Gatwick Airport Northern Runway Project

Statement of Common Ground Between Gatwick Airport Limited and Tandridge District Council – Tracked Version

Application Document Ref: 10.1.9

PINS Reference Number: TR020005

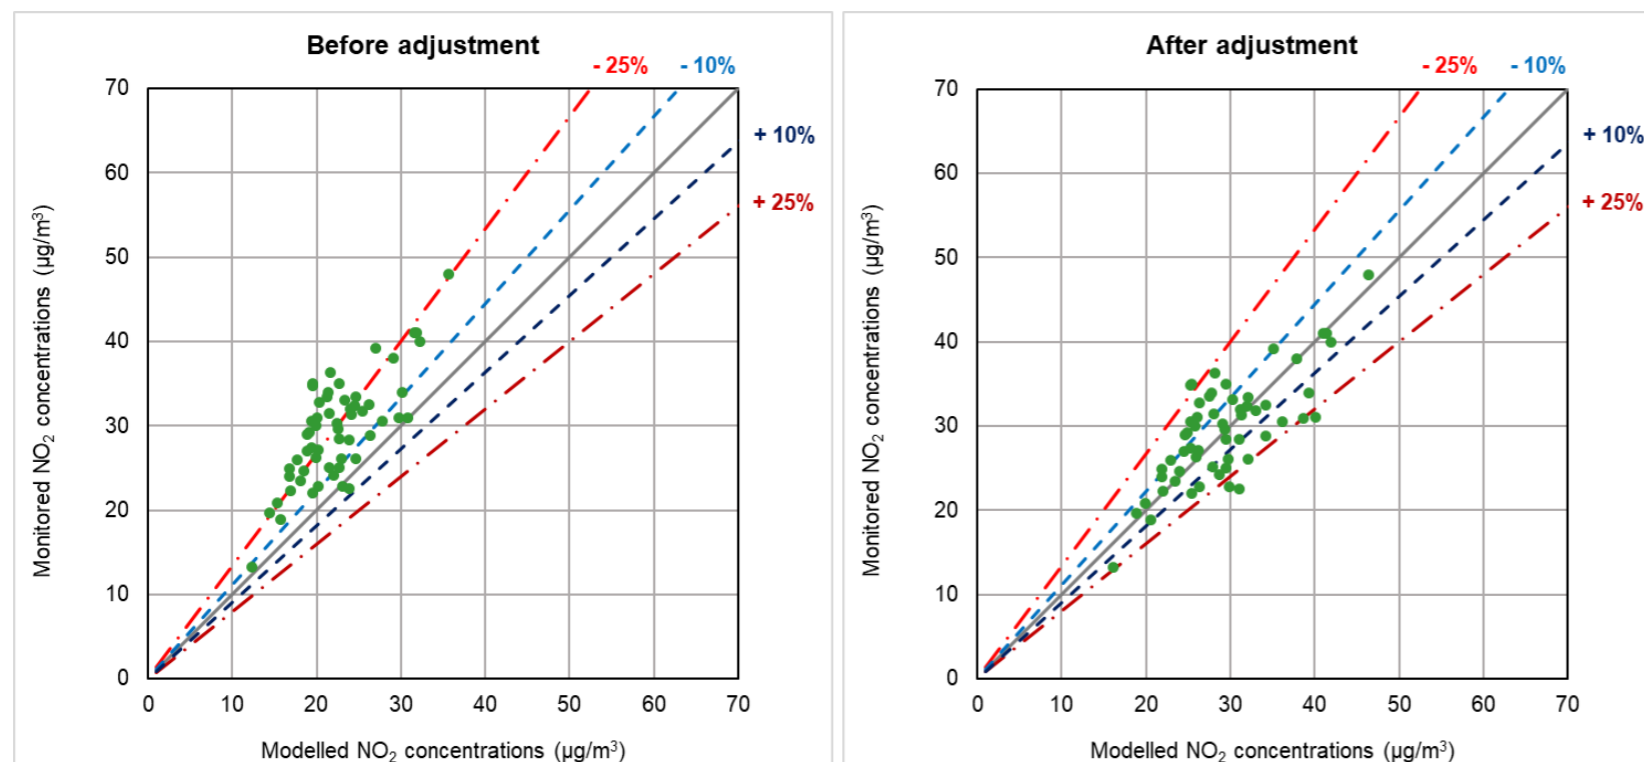
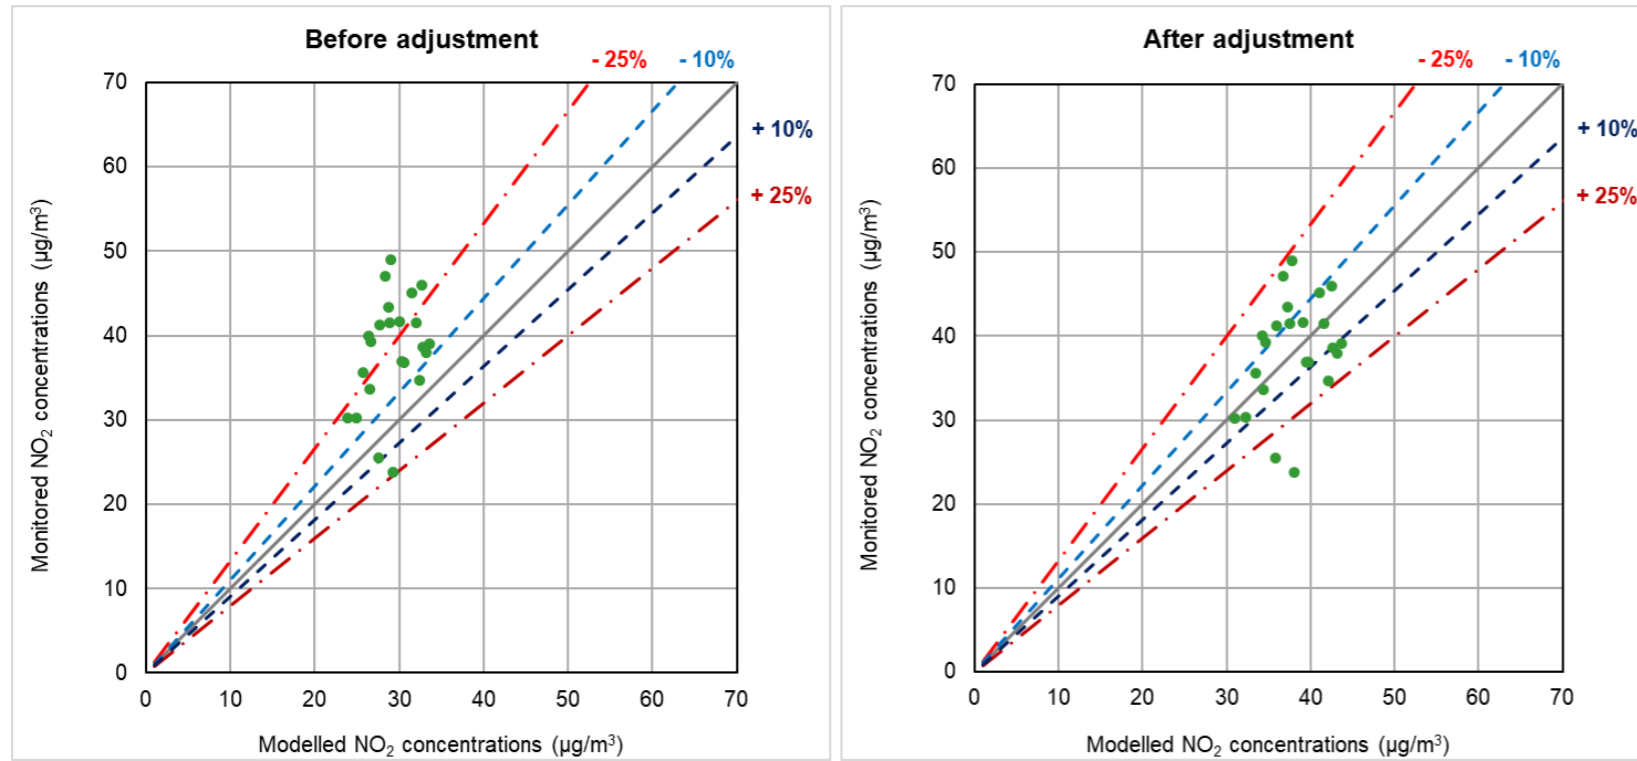
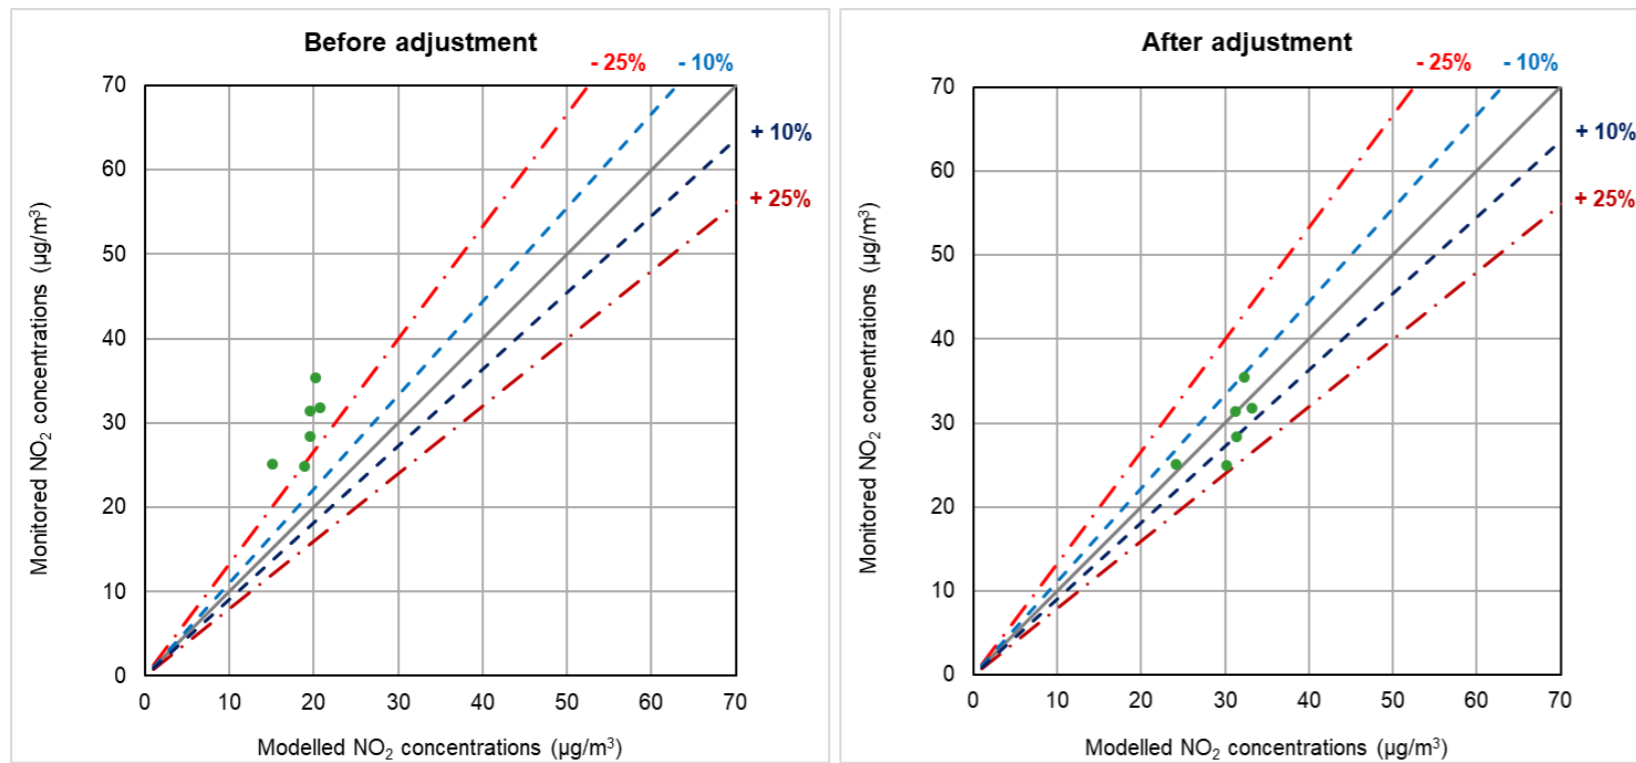
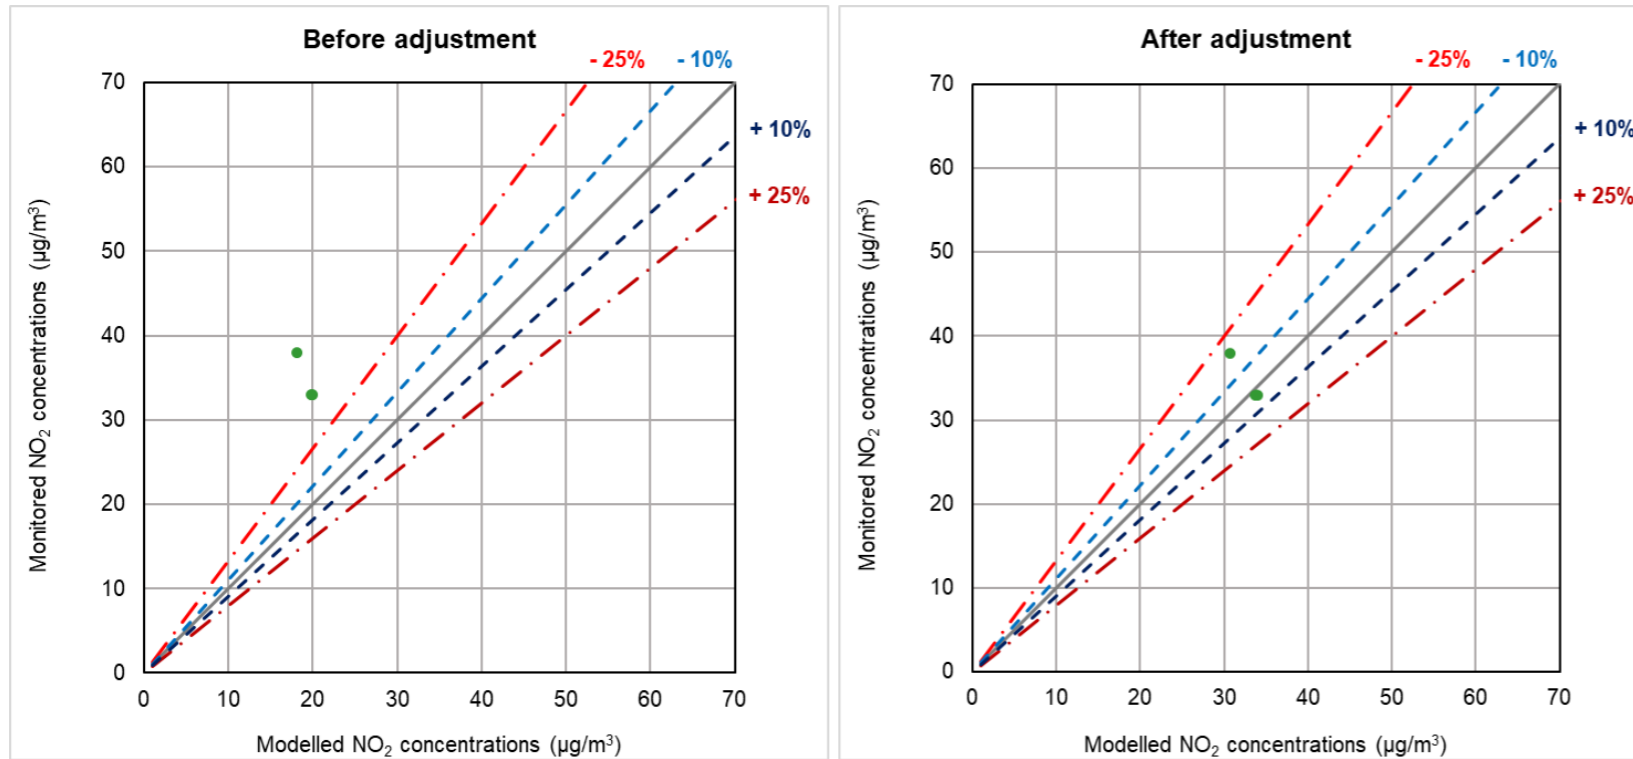
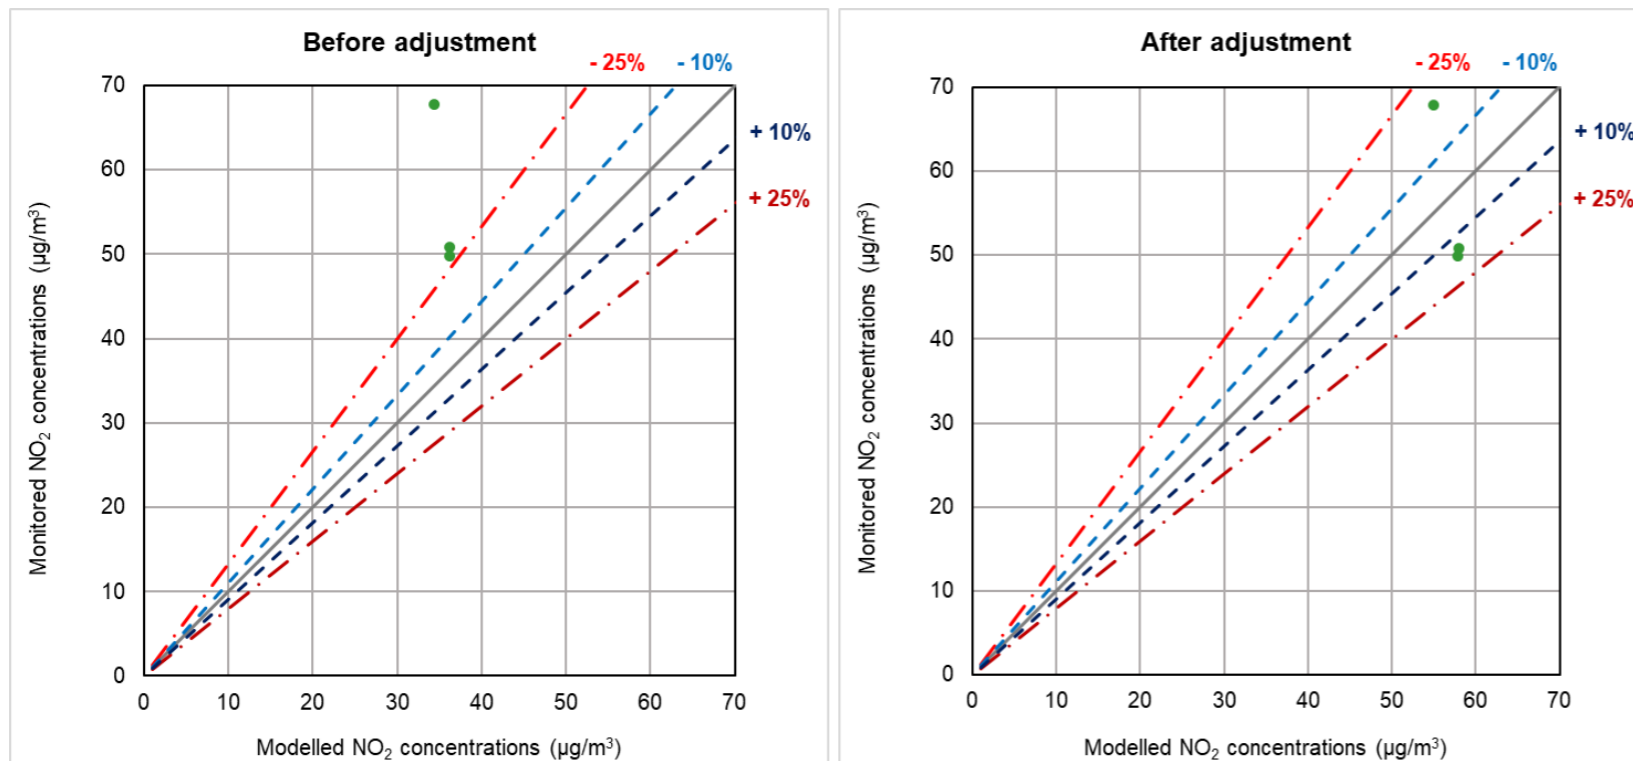
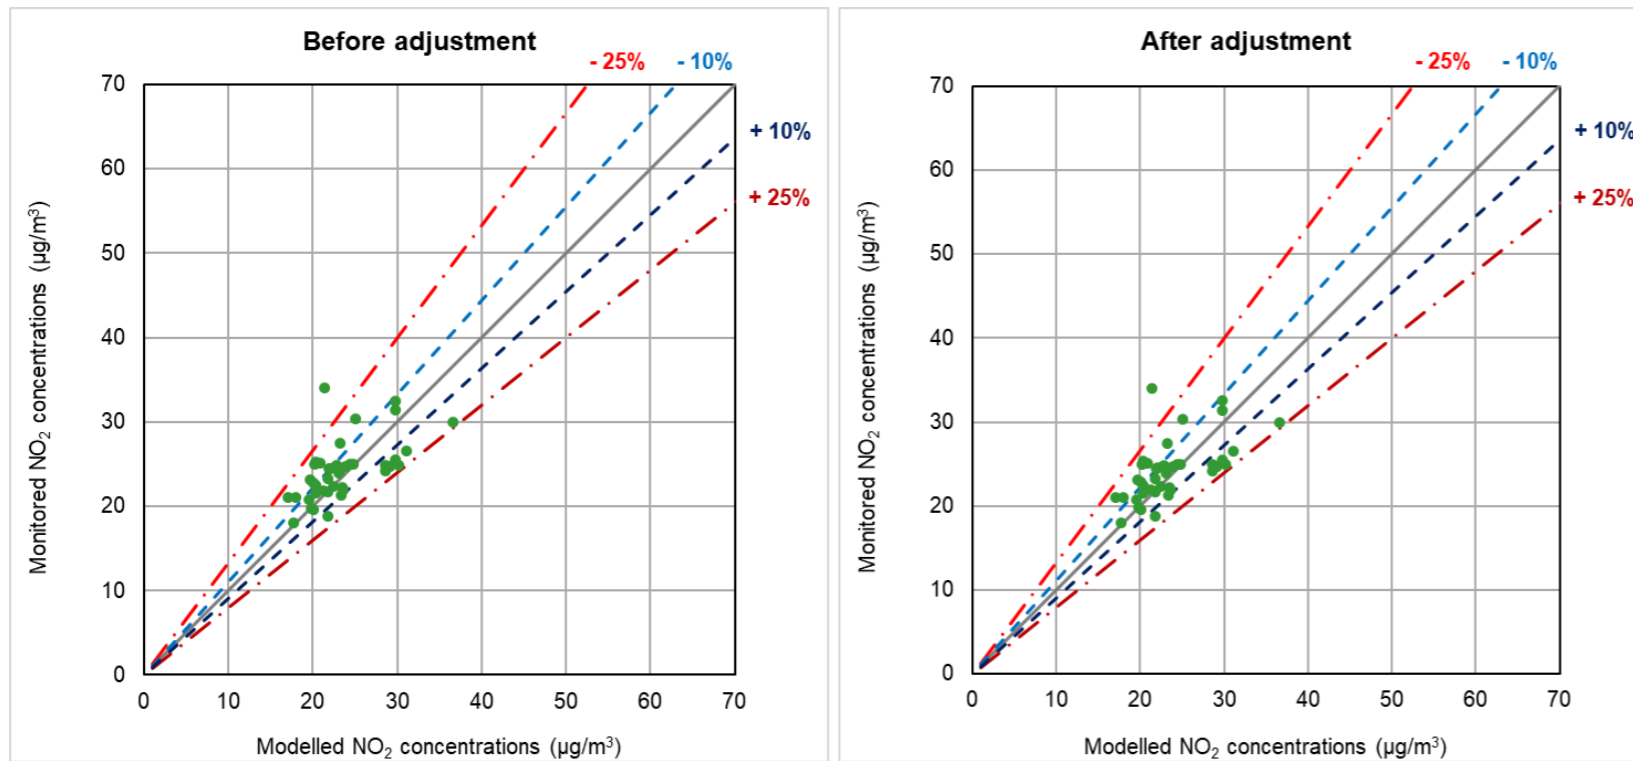
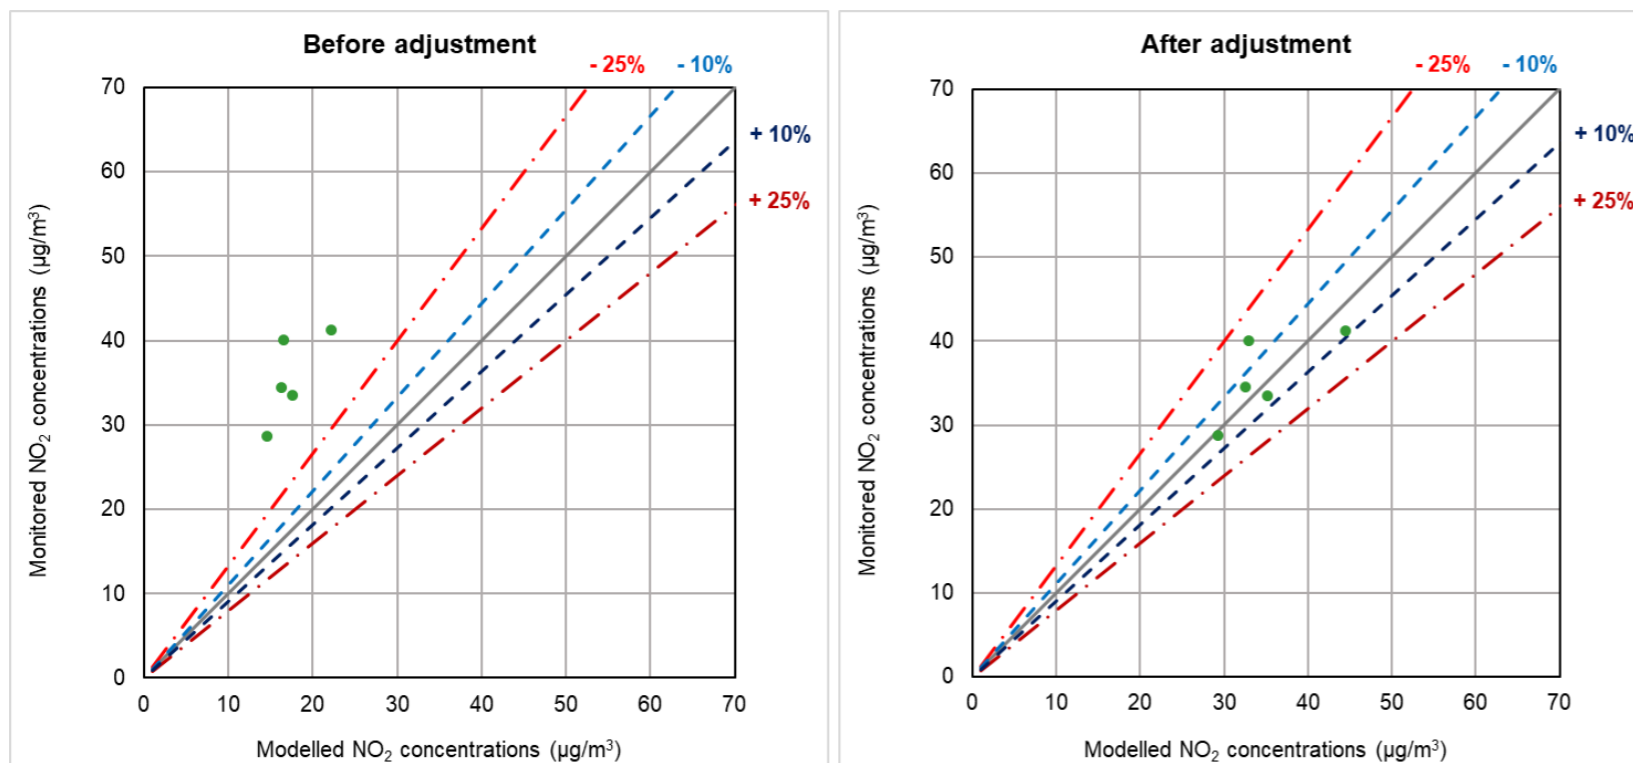
2.2.2.5	Verification zones	<p>TDC disagrees that enough justification was provided for the selection of different verification zones and why the model would be expected to perform differently in each area. A sensitivity test is required to demonstrate that the conclusions of the assessment would not change if a single verification factor were used.</p> <p>Updated position (Deadline 1): Further discussion is required on this point and the request for a sensitivity test examining the use of a single verification factor still remains.</p> <p>Updated position (Deadline 5): Gatwick Airport Limited (GAL) comments in paragraph 3.7.7 of their Response to Deadline 3 Submissions [REP4-031] that the air quality matters submitted by the Joint Local Authorities at Deadline 3</p>	<p>Full details of the model verification process are included in Section 3 within the ES Appendix 13.6.1. Table 3.3.1 provides details on the verification zones used.</p> <p>The verification methodology was agreed with local councils at the modelling methodology workshop in November 2022. Model files and results were provided to the TWG via email 18th August 2023.</p> <p>The process followed during the ES took into account feedback from the local authorities at the PEIR stage and following discussions on the agreed approach.</p> <p>Updated position (April 2024): The Applicant notes that the JLAs have provided a submission on air quality at Deadline 3.</p>	<p>ES Appendix 13.6.1 Air quality Data and Model Verification [APP-159],</p> <p>Appendix A: Response to West Sussex Joint Local Authorities – Air Quality to The Applicant’s Response to Deadline 4 Submissions</p>	<p>Under discussion Agreed</p>

(Appendix A) [REP3-117] will be responded to by Deadline 5. This Appendix of air quality queries prepared by AECOM included a wide range of technical matters.	The Applicant will review this submission and respond accordingly. Updated position (Deadline 5): The Applicant has provided a response to the air quality matter submitted by the JLAs at Appendix A: Response to West Sussex Joint Local Authorities – Air Quality to The Applicant’s Response to Deadline 4 Submissions (Doc Ref. 10.38). The Applicant will respond at Deadline 6 to the JLAs’ review submitted at Deadline 4 [REP4-053]. <u>Updated Position (July 2024): This matter can be marked as ‘agreed’ following consultation with AECOM on behalf of the local authorities on the technical queries set out at Deadline 5 [REP5-073].</u>	<u>[REP5-073]</u> (Doc Ref. 10.38)
